From: Laura Gibbons [REDACTED]
Sent: 21 July 2020 13:14
To: Planning.Responses <Planning.Responses@arun.gov.uk>
Cc: Andrew Wood <Andrew.Wood@arun.gov.uk>; Sarah Burrow <Sarah.Burrow@arun.gov.uk>
Subject: A/77/20/DOC

Having reviewed this application with a colleague we can confirm that we do not recommend discharge of conditions 8 and 9 at this time. We have the following comments which require addressing:

TITLE Preliminary Drainage Strategy Plan			
SCALE 1:200 @ A3		PROJECT No. 23129	
REPORT TYPE DS		DRG. No. 04

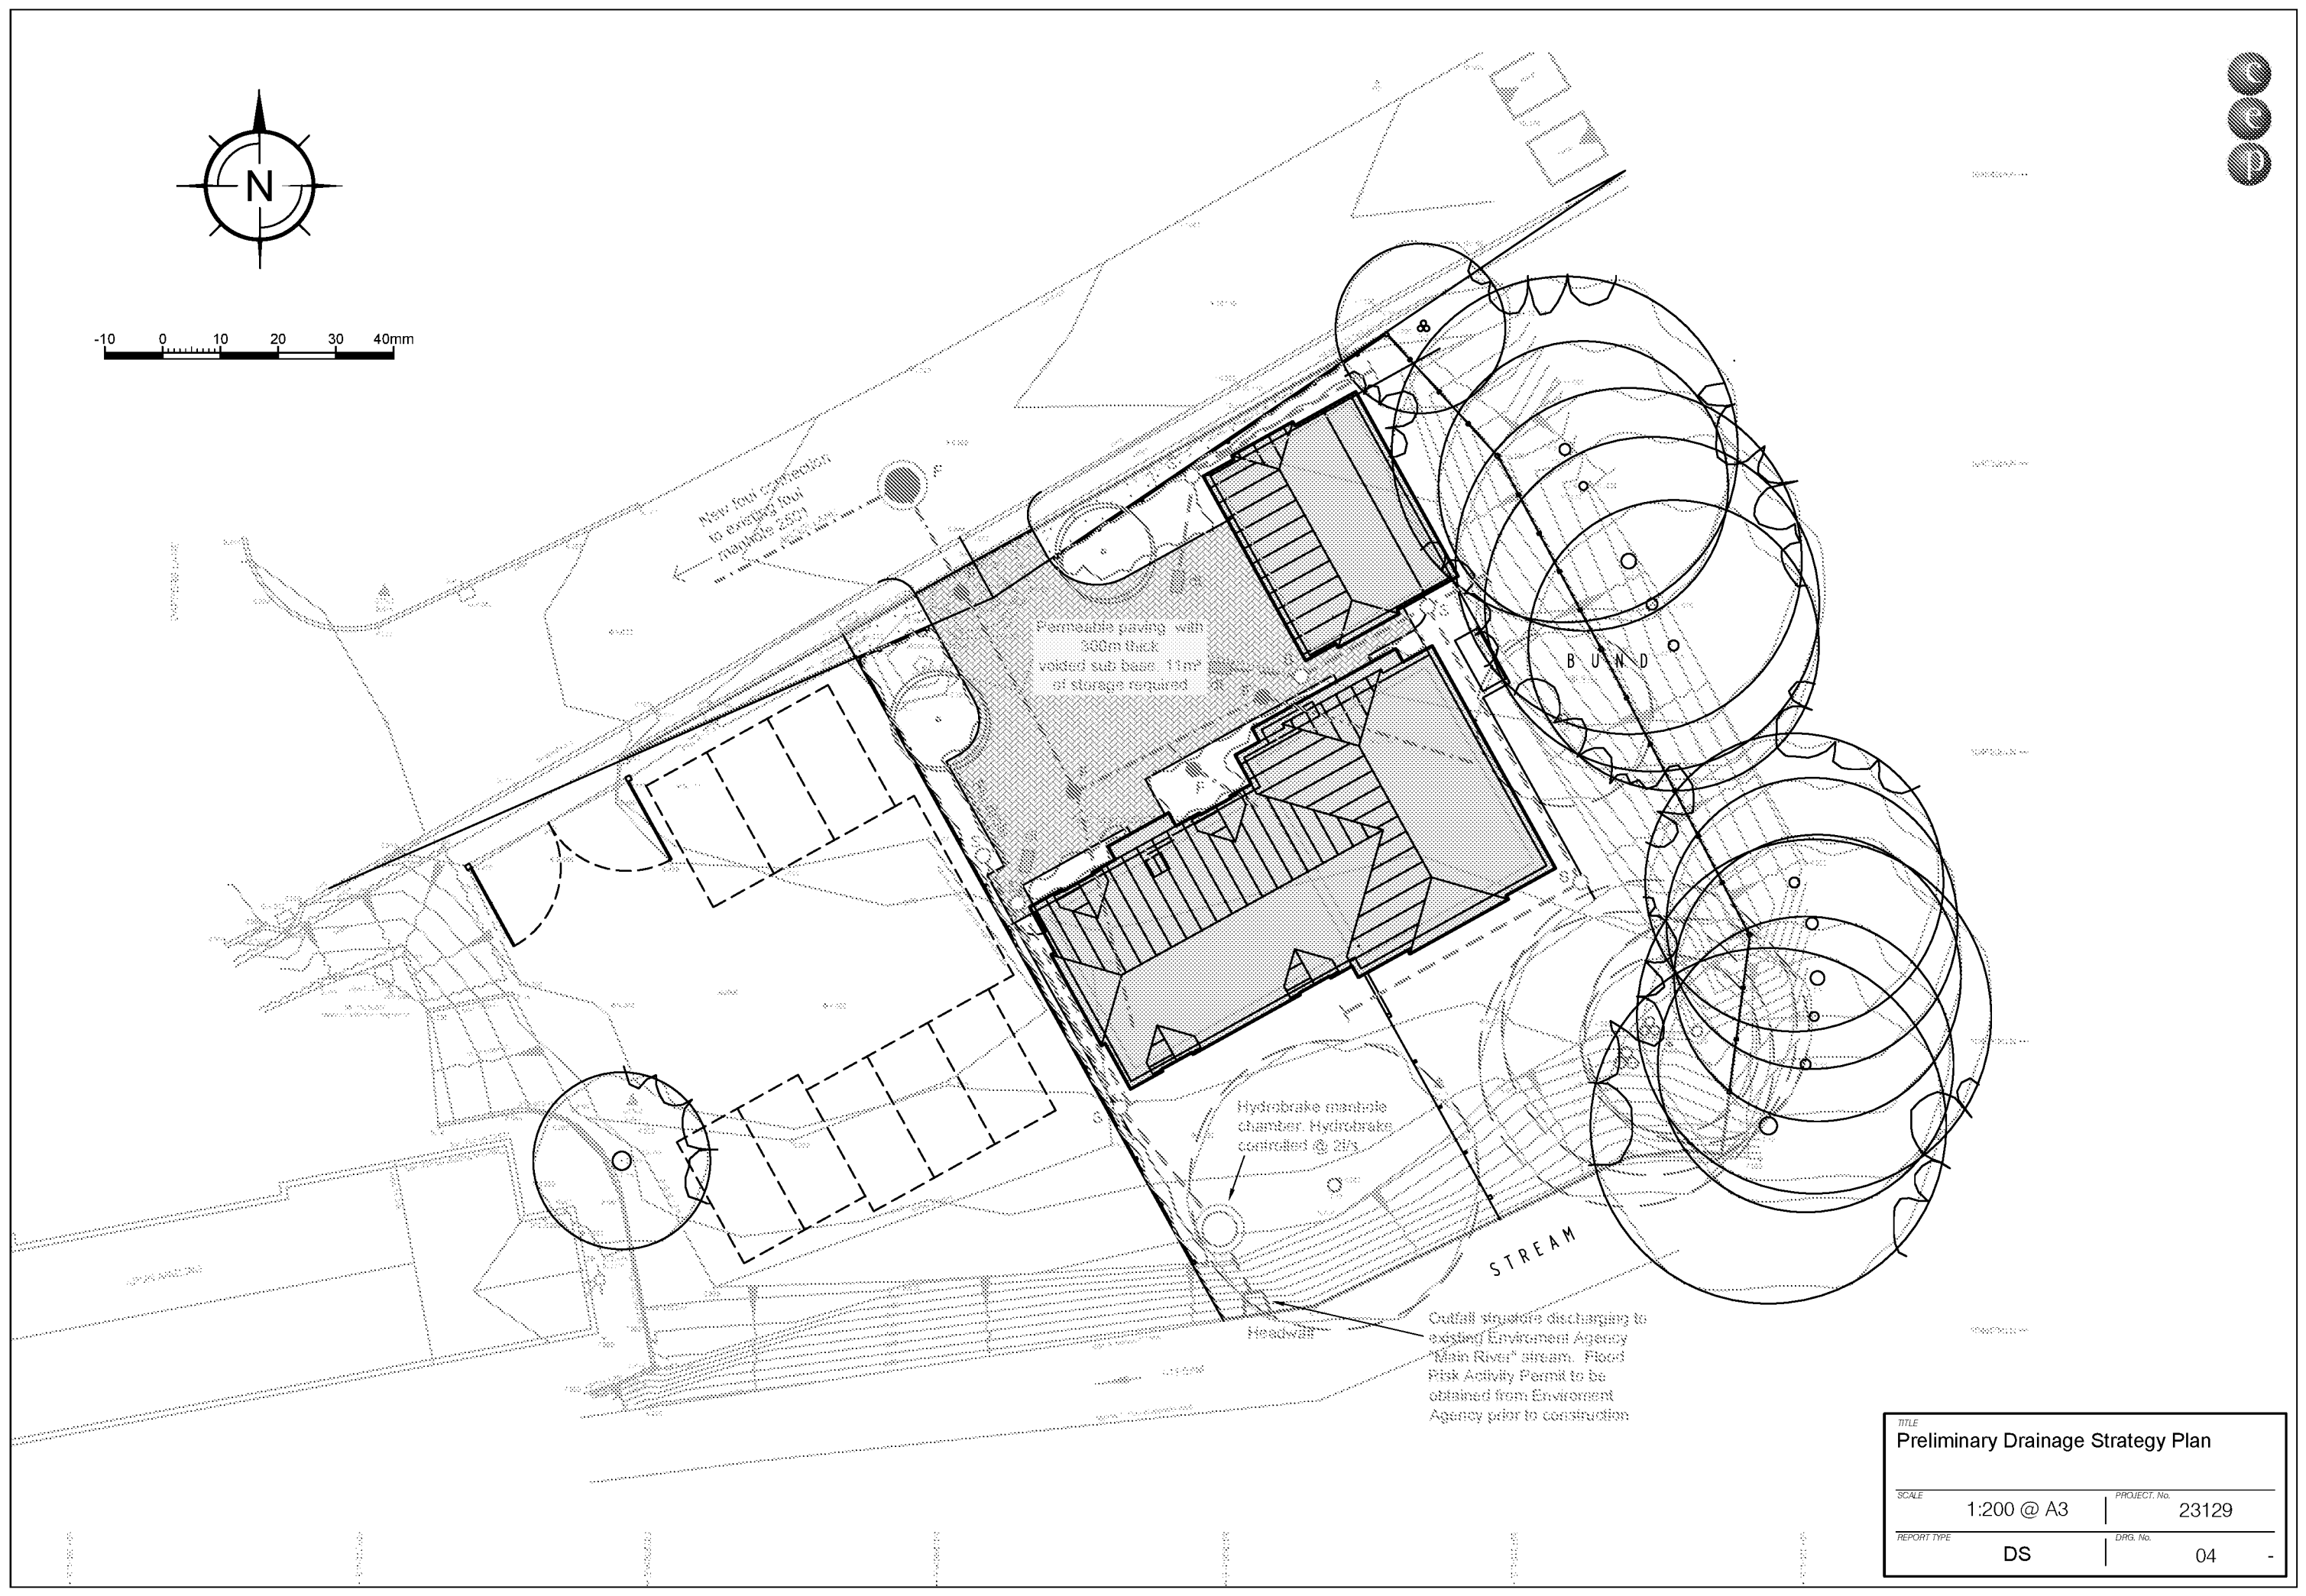
1. Please model a surcharged outfall with water levels equal to top of bank level adjacent to the outfall.
2. Please ensure that all modelled details correspond with those on plan, for example currently there are discrepancies between invert levels modelled and those shown on plan.

CLIENT	TL Homes		
PROJECT	Old Blacksmiths Yard Water Lane Angmering		
TITLE	Proposed Drainage and Levels Layout		
DRAWN	DATE	PROJECT NO.	22346
M Pacifico	July 2020		
ENGINEER	CHECKED	DWG. NO.	
S Doughty		REV.	
SCALE	1:100 @ A1

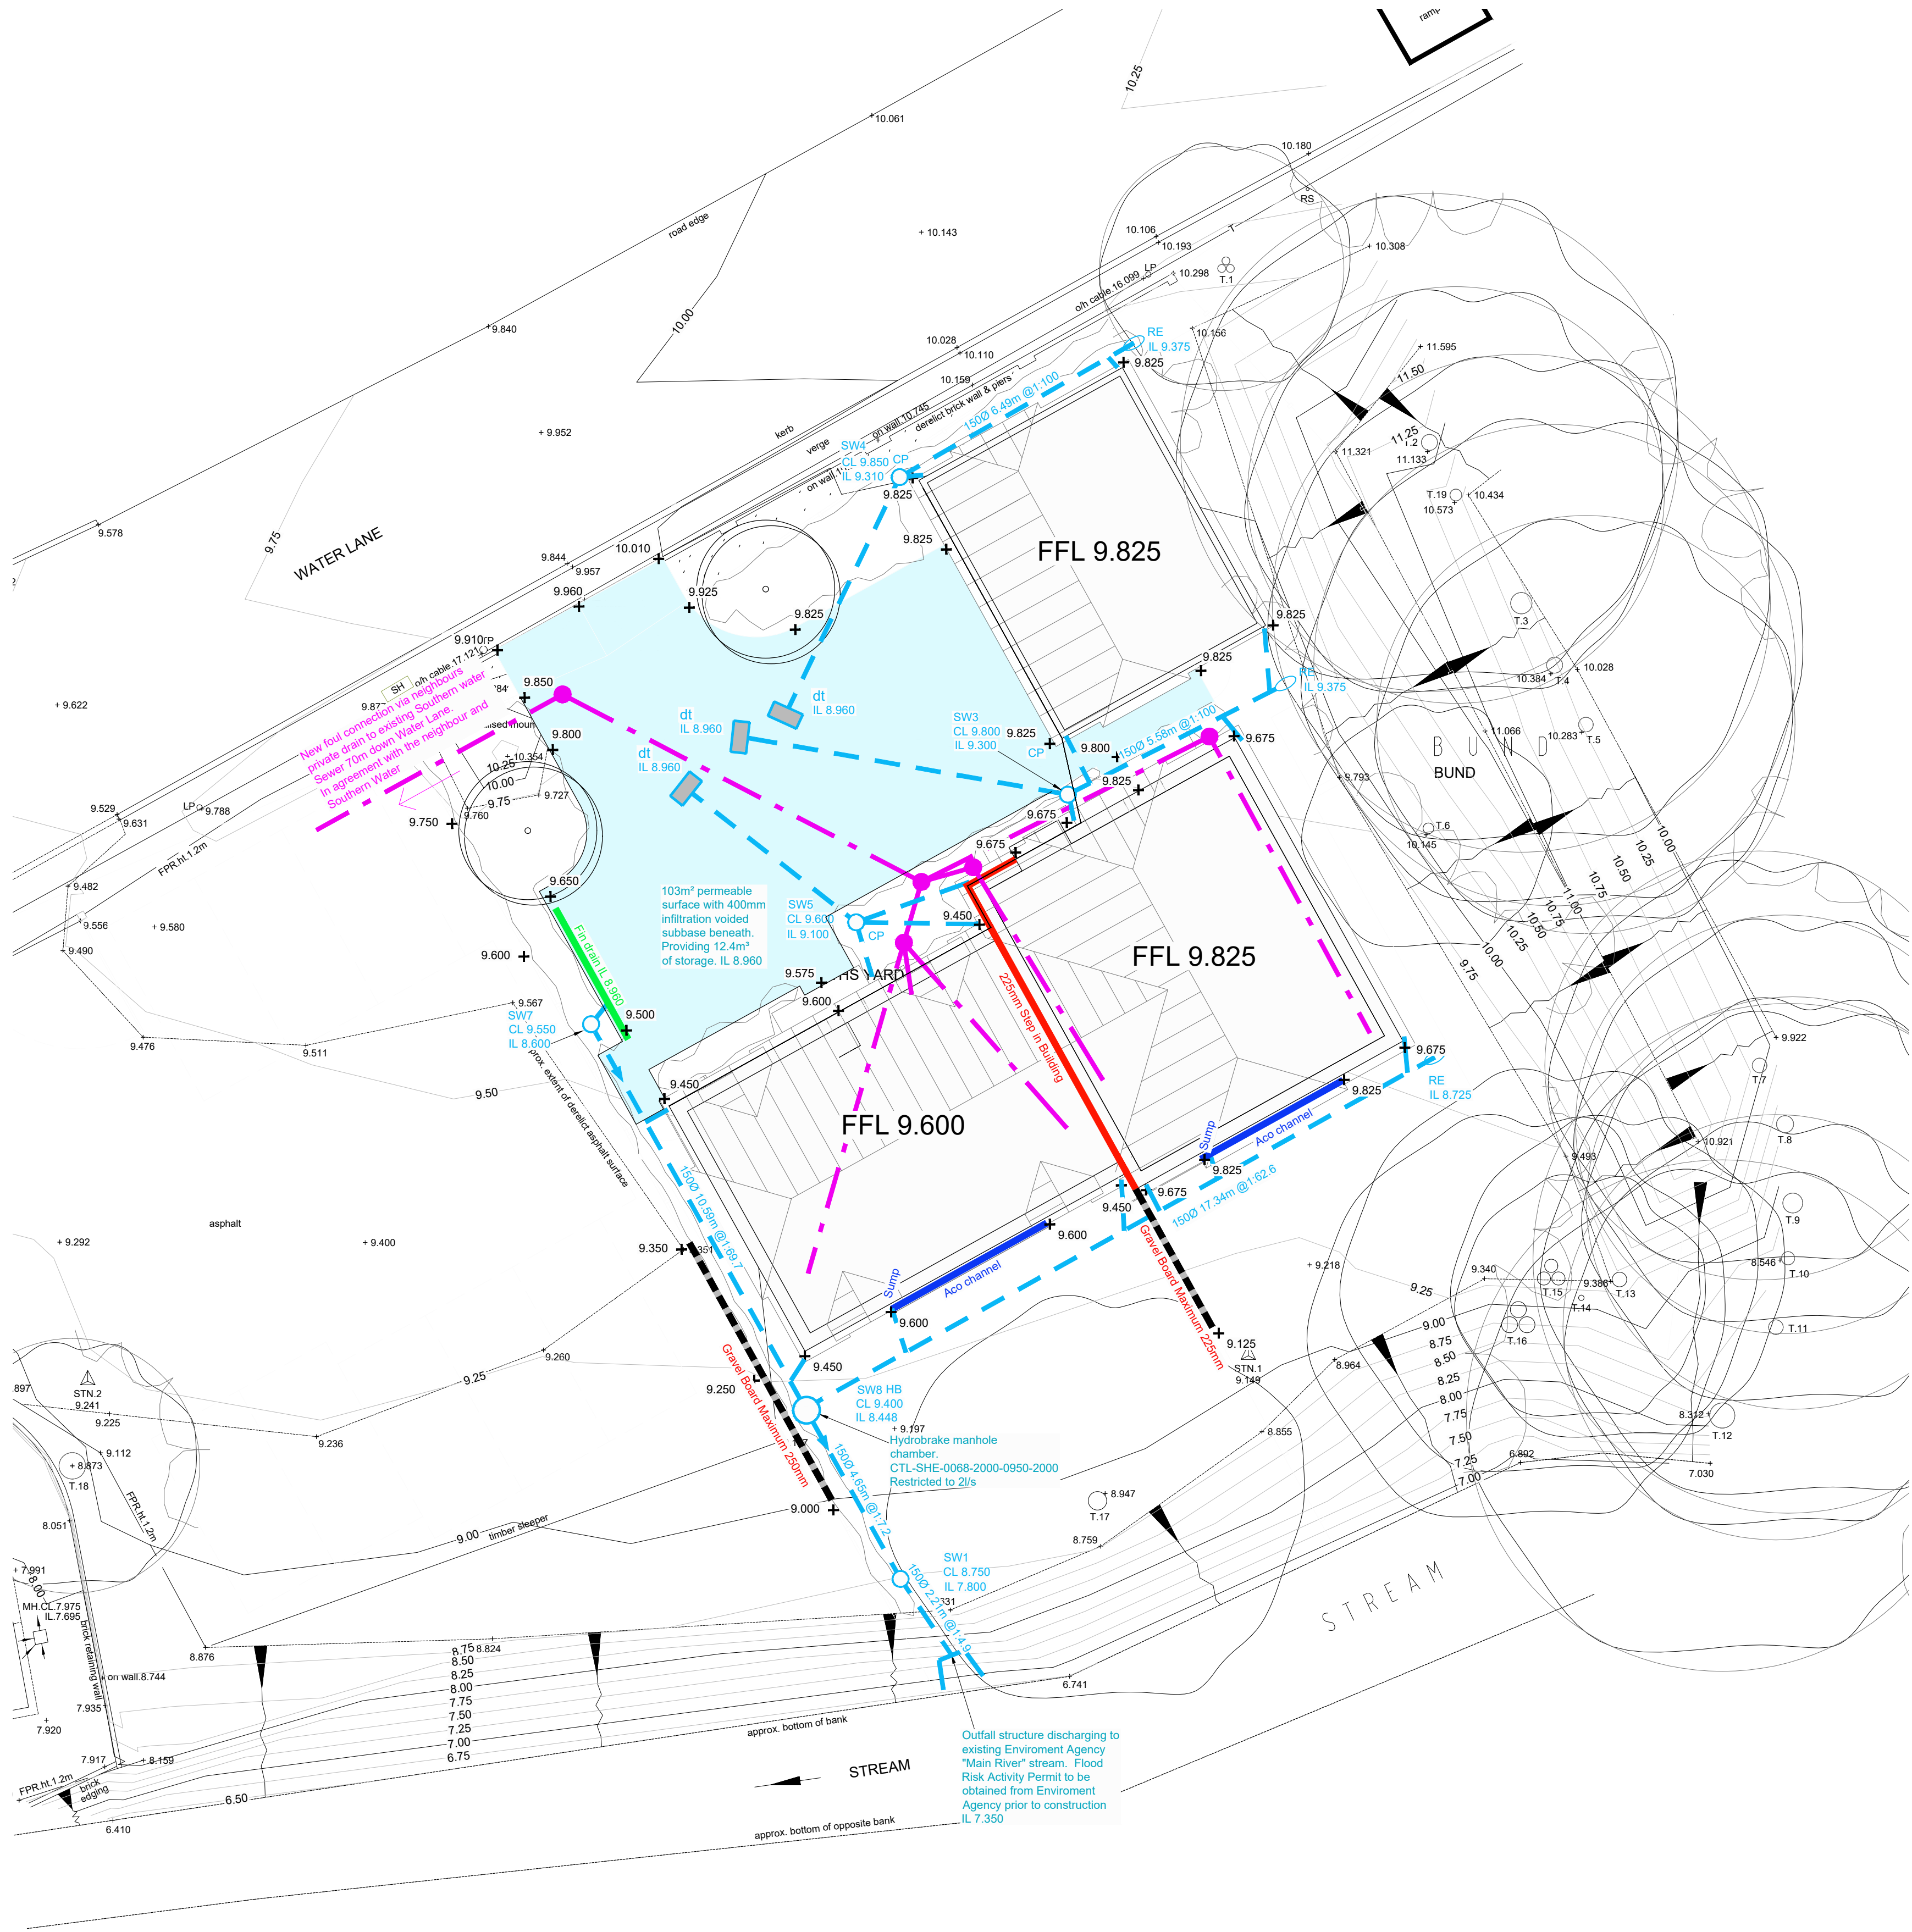
3. The amended drainage strategy states that the sub-base will be left unlined to allow for infiltration when possible. If the sub-base is to be unlined diffuser units must be located 5m away from proposed buildings.

4. The drainage strategy layout is cramped and not clear. Please provide a plan that is to scale and includes the following additional features; a) pipe materials and dimensions for all pipes b) invert levels of diffuser blocks and fil drain c) cover levels and cover types of all inspection chambers/manholes d) finish levels of permeable paving (we note that two ground levels are stated, please make it clear if these are proposed ground levels and include a further level near the garage)

5. Please provide silt traps upstream of all connections into the permeable paving.
6. We note that a Fildrain is proposed to collect water from the permeable paving sub-base and would ask whether collection via a diffuser block may provide a better means to collect water. This is not a point that would warrant us refusing discharge of conditions but is worth considering from a construction and maintenance perspective. We will however need invert levels of the foul drain to ensure no clash between the fildrain and sewer.

7. The layout states the hydrobrake will have a design head of 0.5m, this is inconsistent with the calculations and construction details. Please correct.

MANHOLE SW11 - HYDROBRAKE
(Scale 1:20)

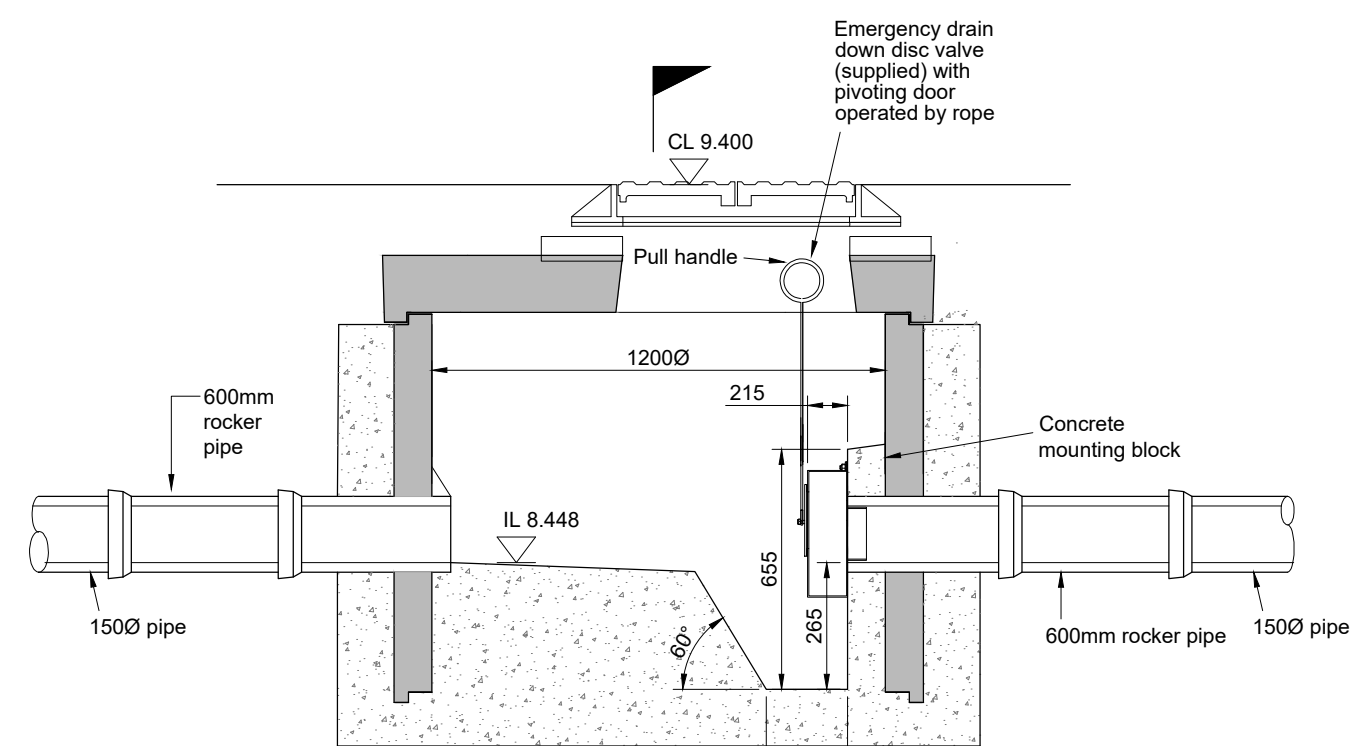
8. The hydrobrake construction detail needs to be site specific, i.e. include invert levels and cover levels. Step rungs should also be provided.
9. Please provide pipe bed and surround details that are consistent with approved document H.
10. Please provide construction detail drawings of permeable paving, aco channel, manholes and catchpits. The permeable paving detail currently provided is not site specific and lacks material specification detail.
11. It is understood that a flood risk activity permit has been applied for, please provide details of this.
